**From:** James Chesworth [redacted]  
**Sent:** 03 November 2017 09:47  
**To:** Anita Gardner  
**Cc:** Planning  
**Subject:** R/202/17/TEL - Substitution of plans - Prior Notification for installation of a 15m monopole and 1No. equipment cabinet, Claigmar Road, Rustington

**Subject:** RE: R/202/17/TEL - Prior Notification for installation of a 15m monopole supporting 3No. antennas, 1No. equipment cabinet and ancillary development. Remove existing 2No. cabinets & 3No. antennas Claigmar Road, Rustington

Drawing Title: PROPOSED SITE ELEVATION

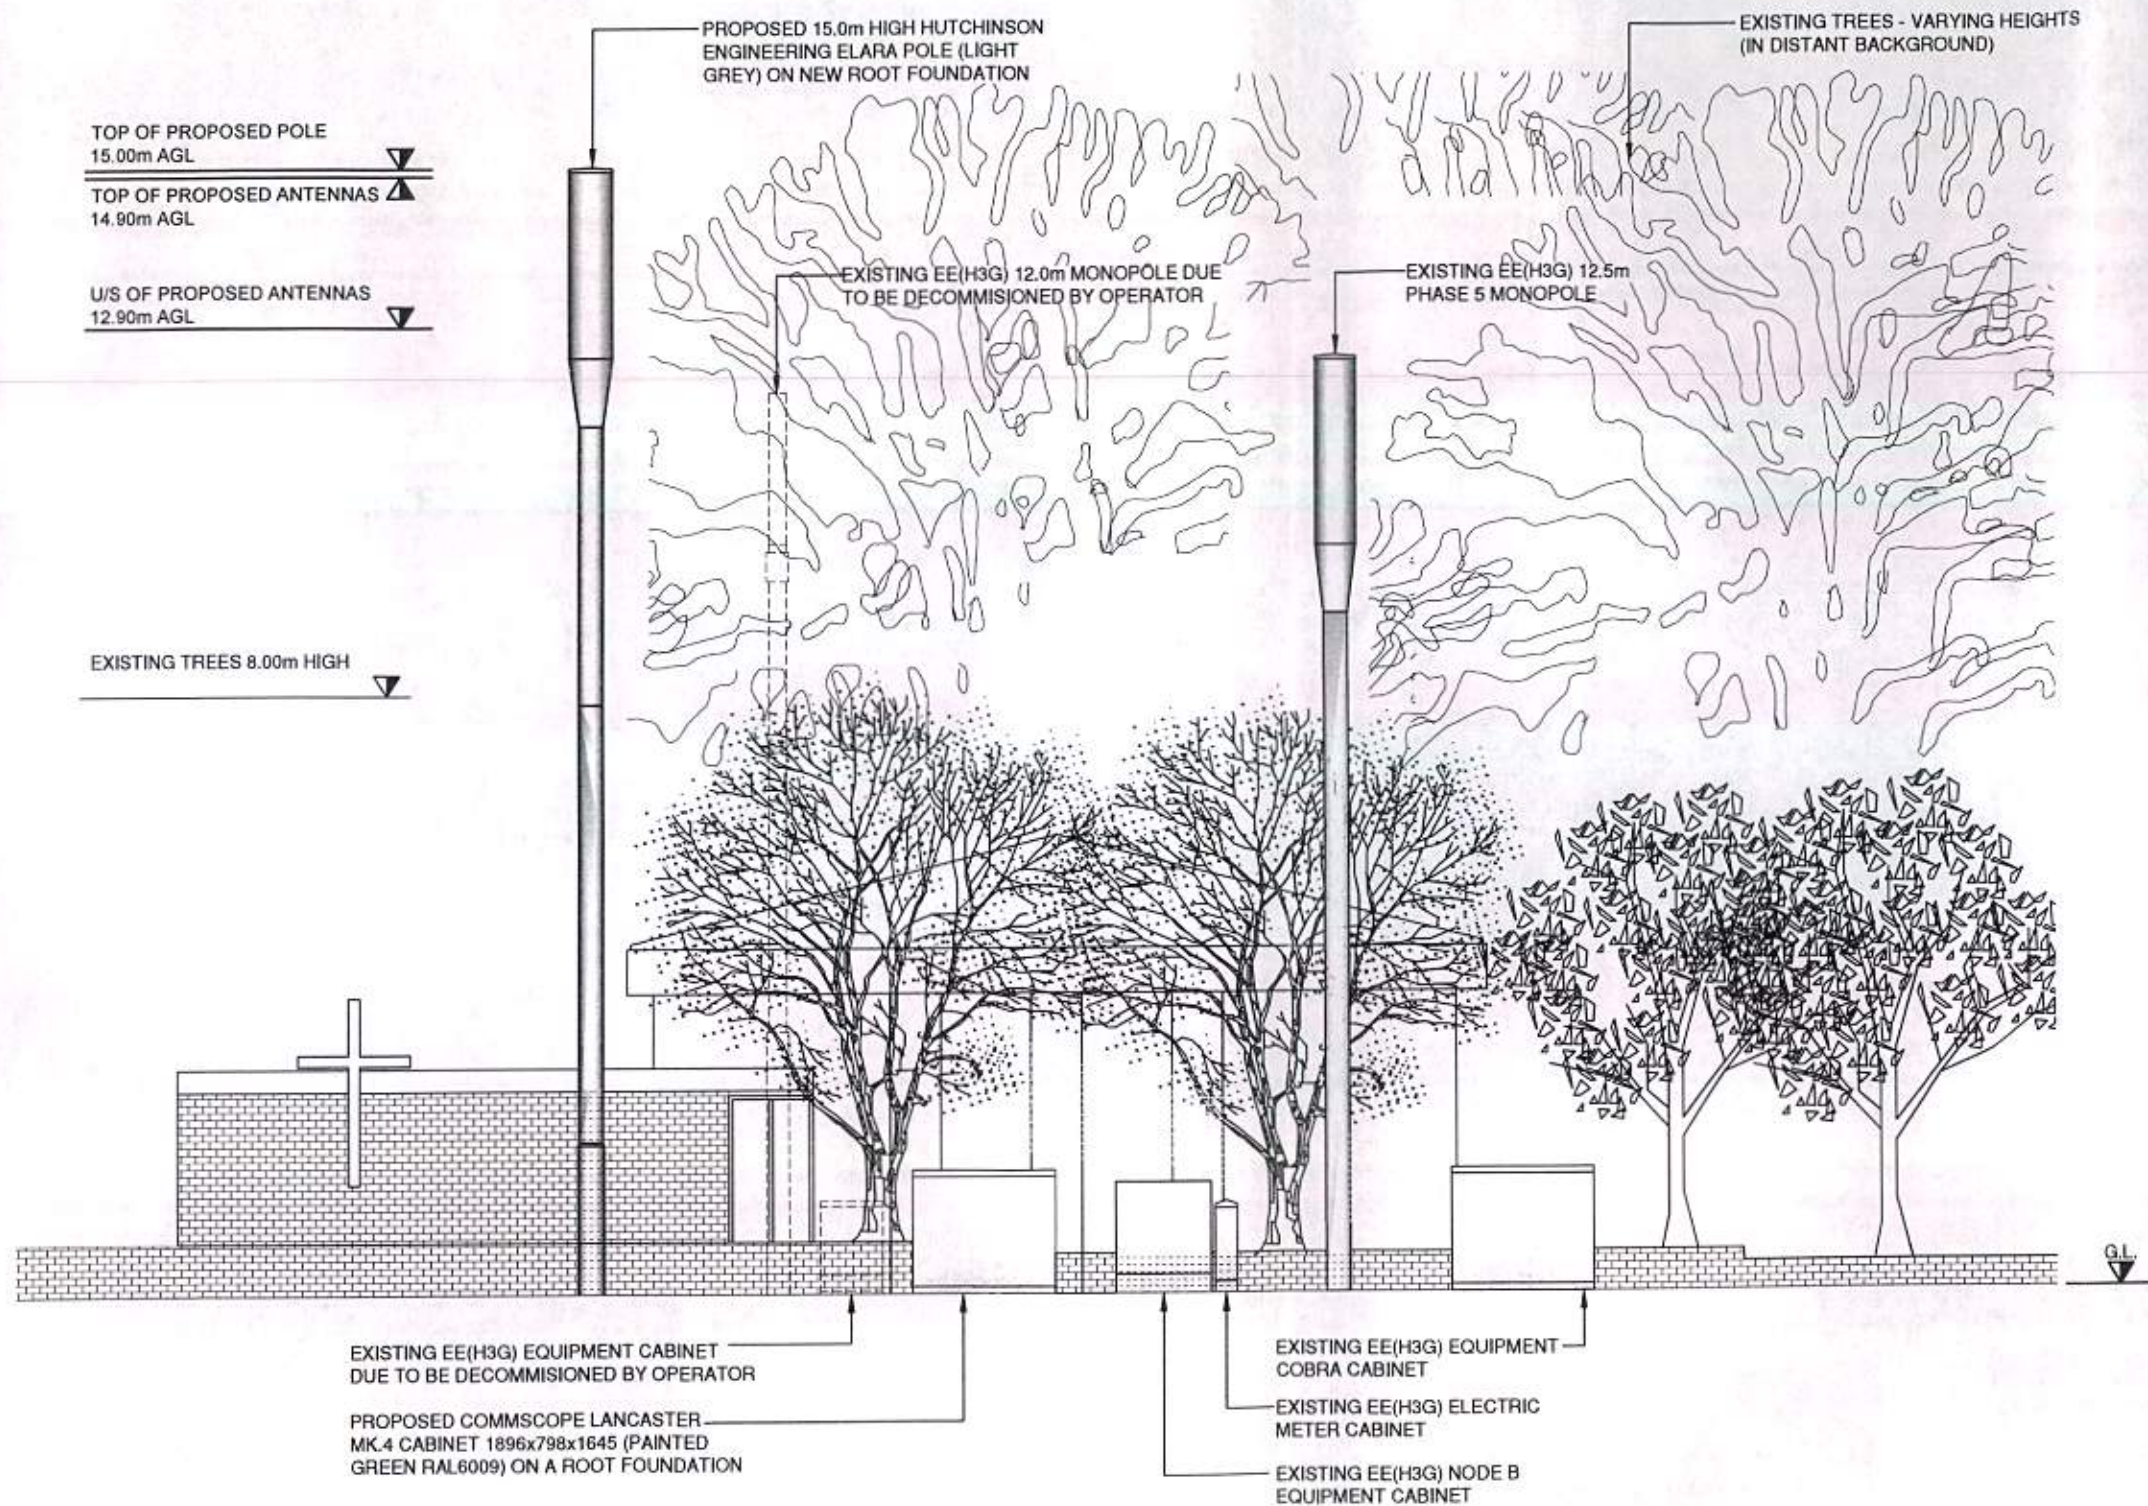
I do consider that the proposed repositioning of the mast 1m to the north would assist in its assimilation in the street scene and without prejudice would appreciate receipt of revised plans accordingly.

- (i) We can confirm that the installation of the proposed monopole and associated equipment is likely to take place after the removal of the redundant EE pole. Unfortunately due to technical reasons (unsuitable ground conditions), it will not be possible to locate the proposed pole in exactly the same location as the redundant pole. However, it will be possible to move the proposed pole approx. 1m further north towards this location. This will have the benefit of keeping all the equipment closer together in this area and taking better advantage of the trees/screening from the trees immediately to the west. If this is acceptable to the Parish Council, we can organise for amended plans to be produced immediately and substituted in the application.

Further to the below, please find attached slightly amended drawings 100D/200D/300D to be substituted in order to help address comments raised by Rustington Parish Council as endorsed by you.
